KIRKLEES METROPOLITAN COUNCIL INVESTMENT & REGENERATION SERVICE

DELEGATED DECISION TO DETERMINE PLANNING APPLICATIONS

Reference No:	2022/60/91966/W
Site Address:	adj, Sunny Mede, Woodhead Road, Holmfirth, HD9 2PX
Description:	Outline application for erection of residential development
Recommending Officer:	Katie Chew

DECISION – OUTLINE PERMISSION

title Site Plan as Proposed  
number 22010D-04-P01  
scale 1:100/1:200/1:500/1:1250  
size A1

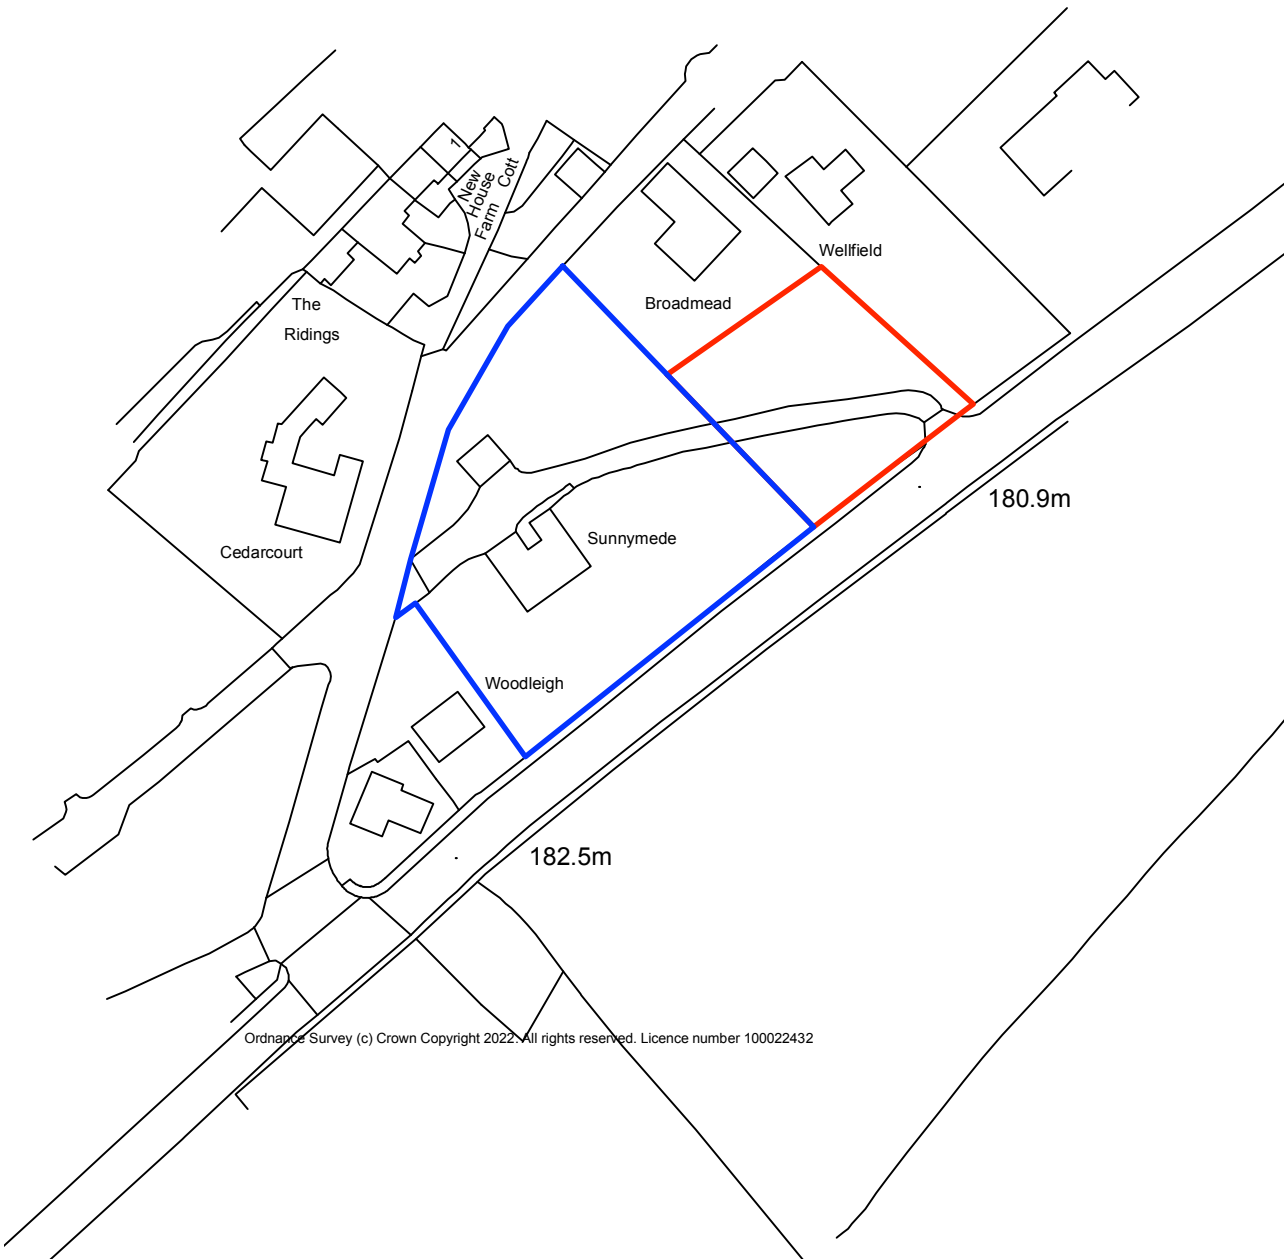
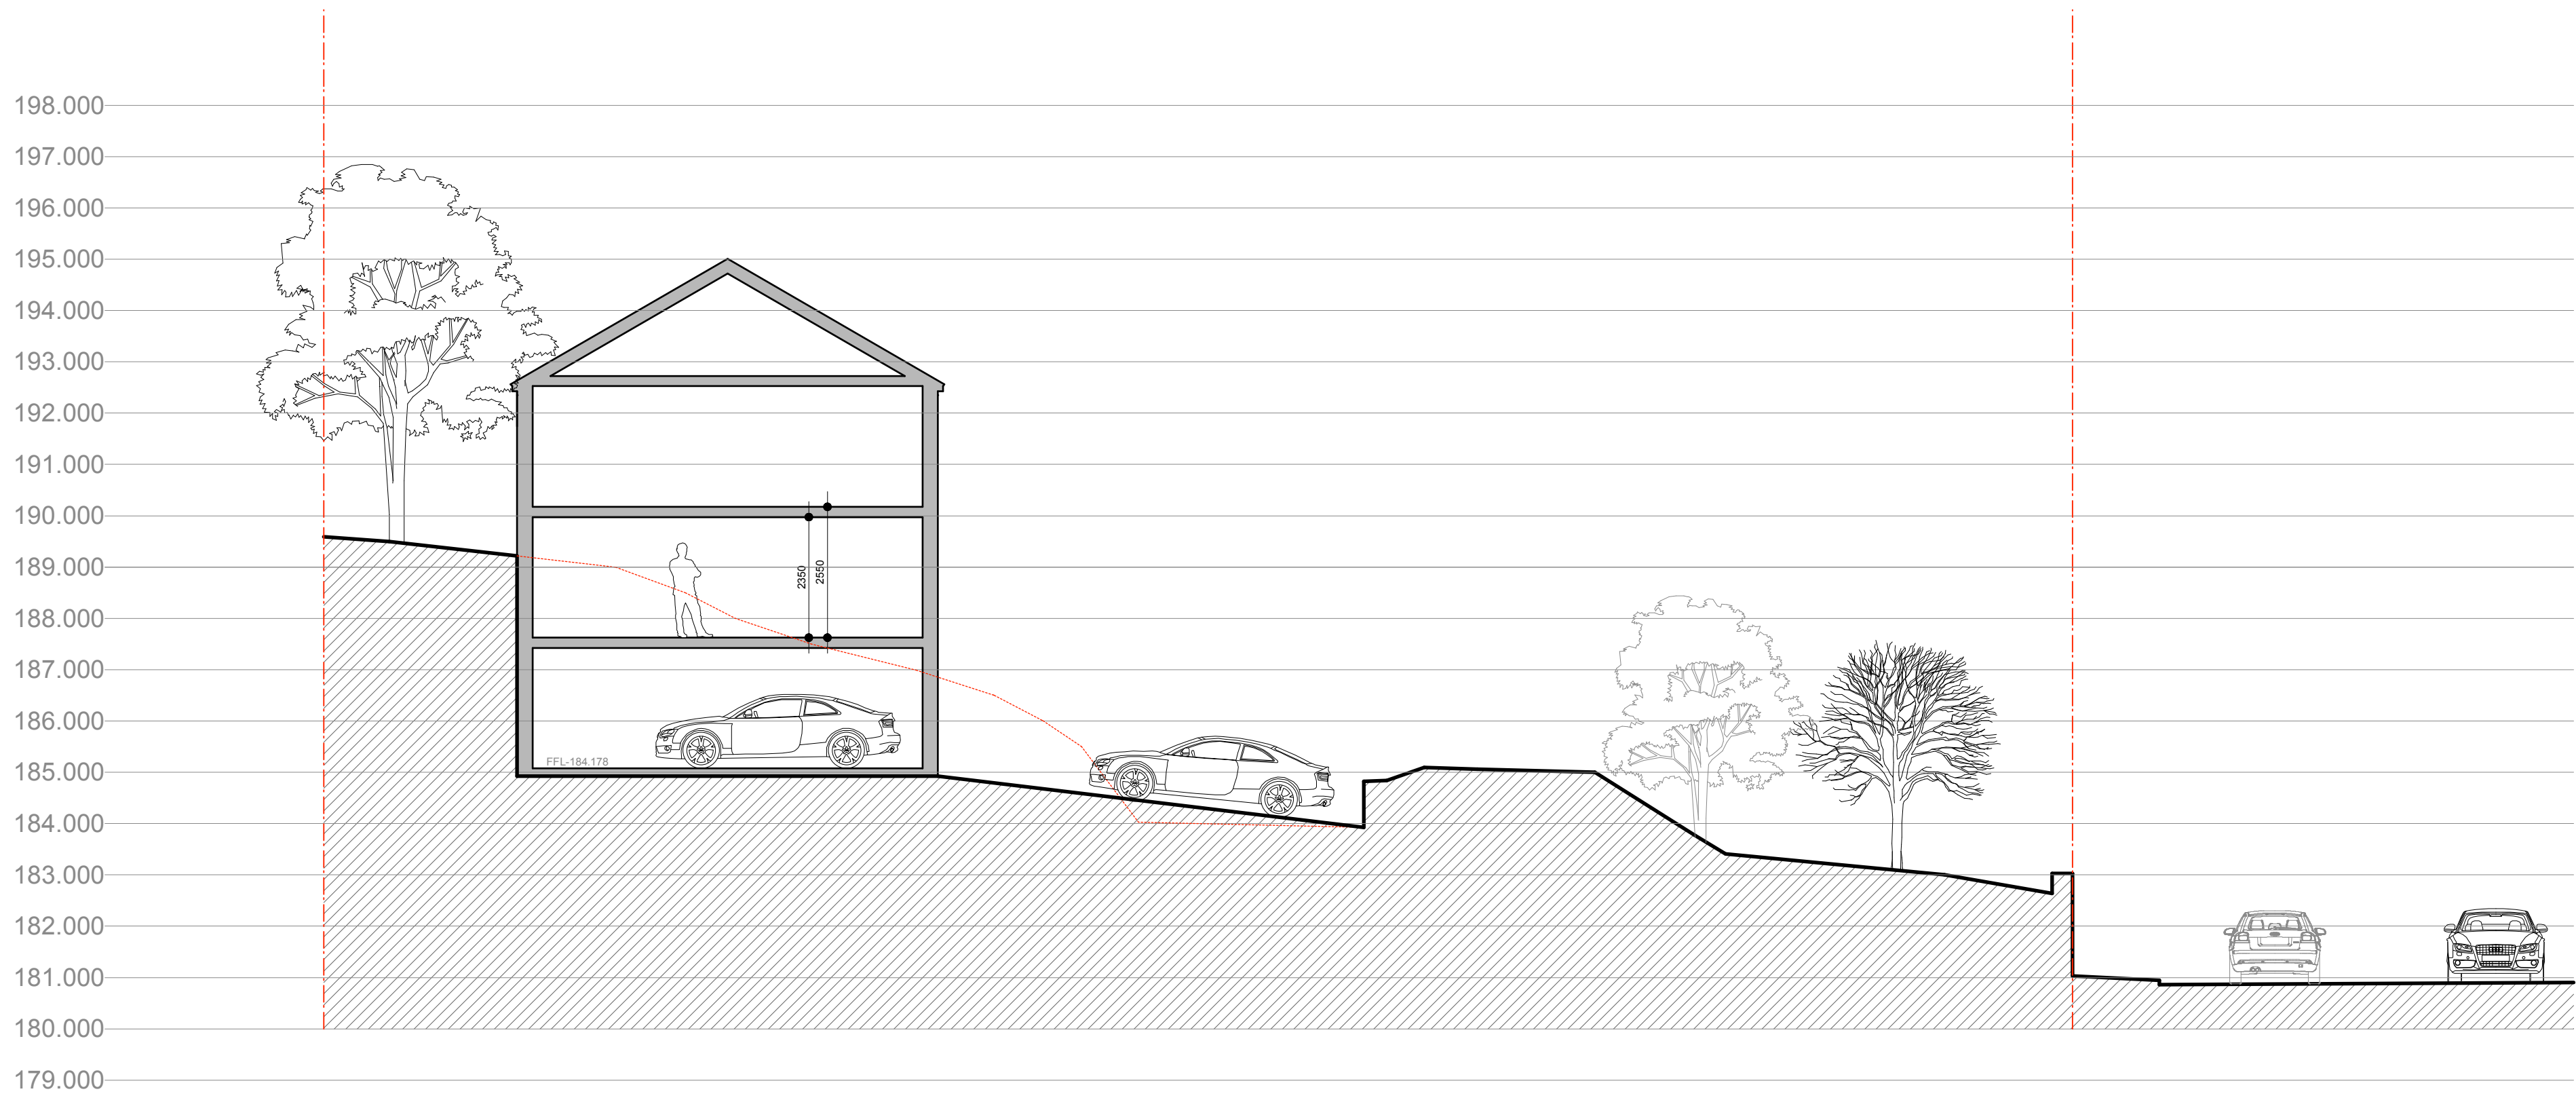
The application proposal is seeking outline consent including access. The indicative plans provided show a detached property within a medium sized plot of land, no details are provided in respect to the number of bedrooms proposed within the dwelling, but a section drawing submitted does indicate that the dwelling is to be 3 storeys in height. However, this can only be deemed indicative as details of scale are not known at this time. Off street car parking is also proposed for 2 vehicles, with swept paths provided indicating that vehicles can turn within the site to exit in first gear. Garden areas are be provided to the front, sides and rear of the dwellinghouse.

Paragraph 7.19 of Principle 6 states that for houses two-storeys or above, there should normally be a minimum of a 2m distance from the side wall of the new dwelling to a shared boundary. In this instance (as shown on the indicative plans) the proposals would be able to meet the requirements of Principle 6, the applicant should ensure that this is still the case within any reserved matters application.

In respect to scale, the dwelling shown on the indicative plans submitted is to be 3-storeys in height with a ridge height of approximately 10m. Given the proposed location of the dwelling, and design of neighbouring properties it is considered reasonable to require any reserved matters application be no more than two storeys in height, although this would still need to be supported by a section drawing showing the difference in land levels between the proposed dwelling and neighbouring property 'Broadmead' located to the rear of the site. This is in the interests of both visual and residential amenity (discussed in the following section of this report).

Garden/amenity areas are indicated to the front, rear and sides of the dwelling although details in respect to landscaping are minimal, the plans do show the removal of numerous trees within the site and given the level of excavation shown within the submitted section plan and stairway shown to the side of the property, there will be raised gardens and varied land levels throughout. This would need to be considered further at reserved matters stage given that this garden area relates to soft landscaping. However, it is considered that a usable amenity space would be able to be achieved for both the existing dwelling (within which the proposal is garden of) and also the proposed dwelling.

In respect to overlooking, given the large separation distances between the site and this neighbouring property, it is considered achievable that proposals submitted at Reserved Matters stage could provide a distance of 21m between any habitable room windows. In addition, although scale and layout could change within the reserved matters application, due to the large separation distance officers deem it possible for a detached dwelling to be constructed without appearing overbearing in nature or causing concerns with regards to overshadowing. In line with comments made within the visual amenity section of this report, the proposed dwelling should be no larger than two storeys in height.

Access has been applied for as part of this outline application. The submitted plans show that the existing access is to be used for the new dwelling but be terminated for the host dwelling Sunny Mede. The host dwelling will gain access from the driveway which currently exists off Shaw Lane. Car parking is shown for 2 vehicles with swept paths shown indicating how vehicles could turn within the site and exit in first gear. Highway officers raised no concerns in relation to access or parking but did request that within any reserved matters application details should be shown for bin storage and collection pads for the dwelling. As the access would be in effect one driveway to serve the host property with a turning / parking spaces adjacent to the dwelling it is considered that a 4+

5. The residential development hereby approved shall not exceed a maximum of one dwelling that is no more than 2 storeys.
